Engineers Comments Regarding Surface Water Drainage

Application Reference:	LU/207/26/PL	Reviewer Reference:	ADC/EXT5/AF
Planning Officer:	Hebe Smith	Date of Review:	05/10/2026
Site Name:	Burger King Restaurant Worthing Road Littlehampton BN17 6LE		
Application Description:	Installation of a drive-through lane to serve the existing Burger King restaurant. This application affects a Public Right of Way. Is in CIL Zone 4 (Zero Rated) as other development.		
Assessment Number:	1

Appendix D – Drainage Layout

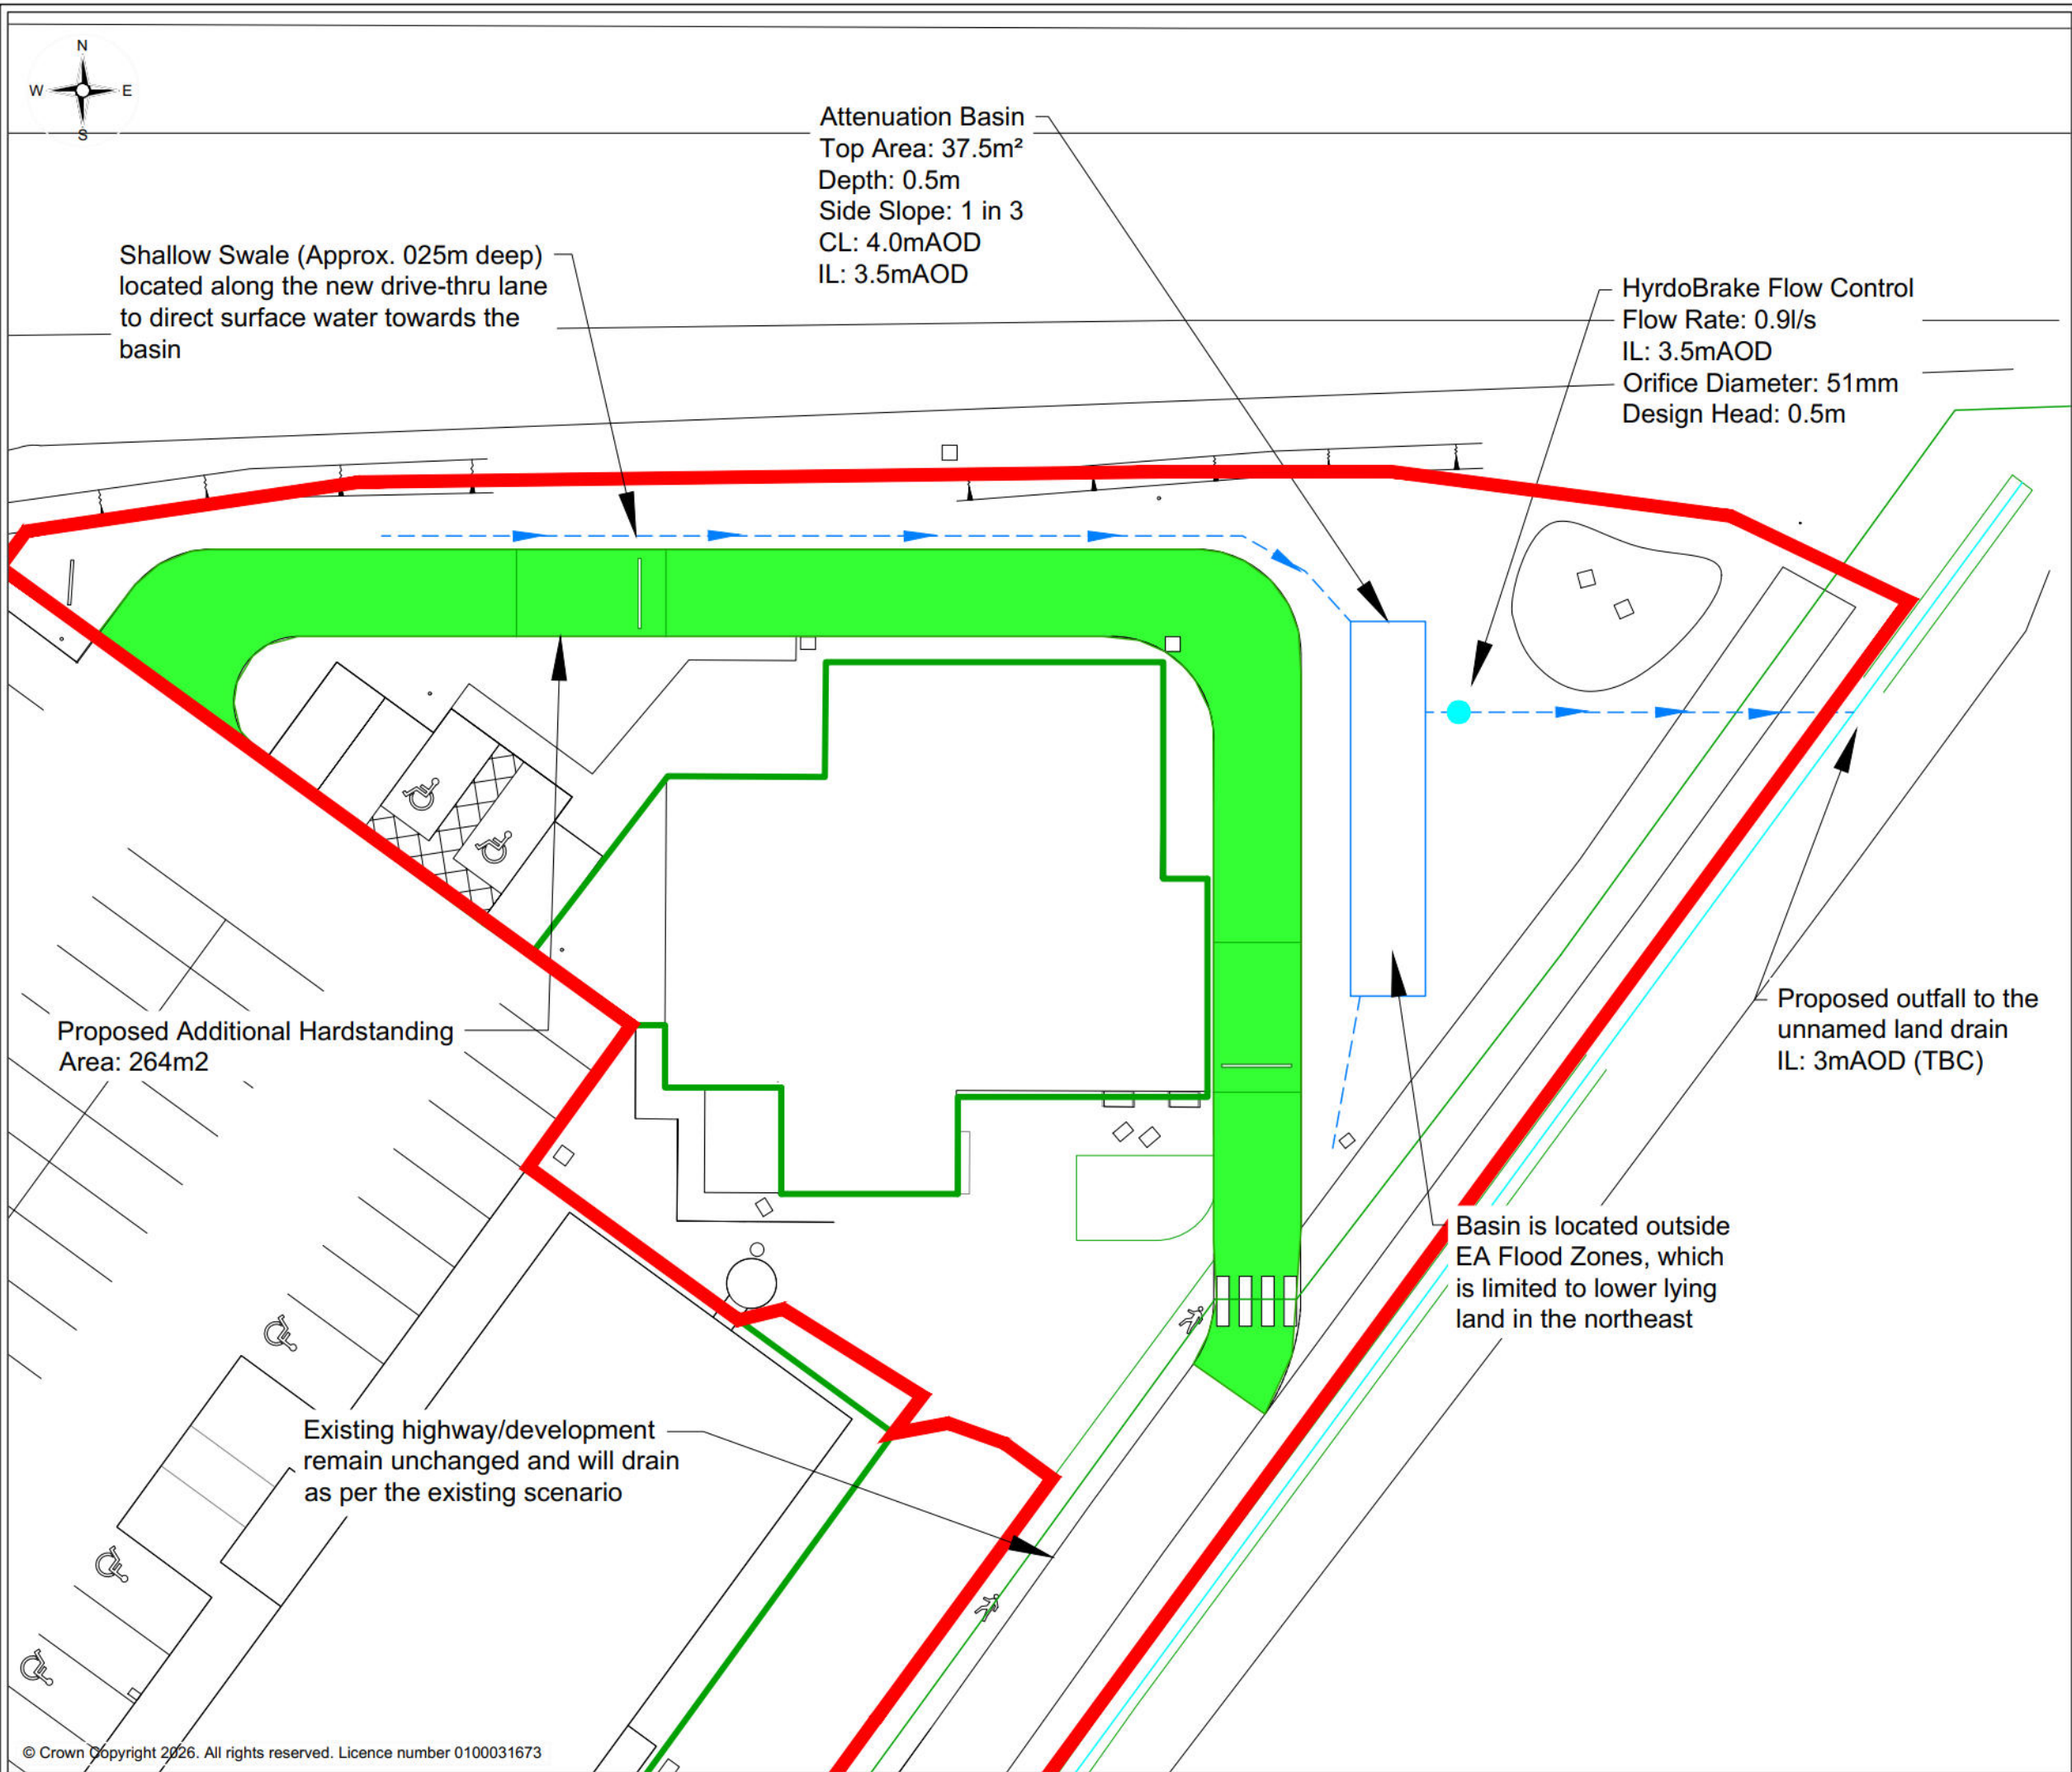
- 1.3. The proposed connection to the watercourse would be acceptable in principle if infiltration is not feasible. The feasibility of this solution should be demonstrated with finished ground levels and below ground drainage levels against topographic survey which includes the watercourse.

- 3.1. A drained areas plan should be provided highlighting a hatched area of impermeable runoff. The calculations should also include bodies of water such as swales and basins where rainfall on these areas increases runoff to the drainage system.

- 3.2. The design peak flow of 0.9 litres per second does not comply with the requirements of Standard 3 and should be based upon the greenfield runoff rate for the drained area. A 'relaxation factor' no greater than 5 times the greenfield runoff rate may be applied where evidence is provided that demonstrates why greenfield runoff or 3 l/s/ha rates cannot be achieved. Rates as low as 0.2 litres per second are sometimes achievable with correct blockage mitigation by filtering the runoff prior to reaching the flow control.

- 3.5. The drainage layout should include sufficient finished ground and below ground drainage levels information to demonstrate feasibility subject to technical design. This should be based upon topographic survey.
- 3.6. The existing drainage for the drainage areas within the red line boundary which are not served by the new drainage system should be highlighted. Any areas of existing paving which drain into the new drainage system should be included in the calculated drained area.
- 3.7. Exceedance paths should be shown on the drainage layout plan.
- 3.8. Further information is required to confirm the design is in accordance with the requirements of the NSfS (Standard 3). The current submission does not demonstrate compliance with the standard, therefore, we **Object** to the development.
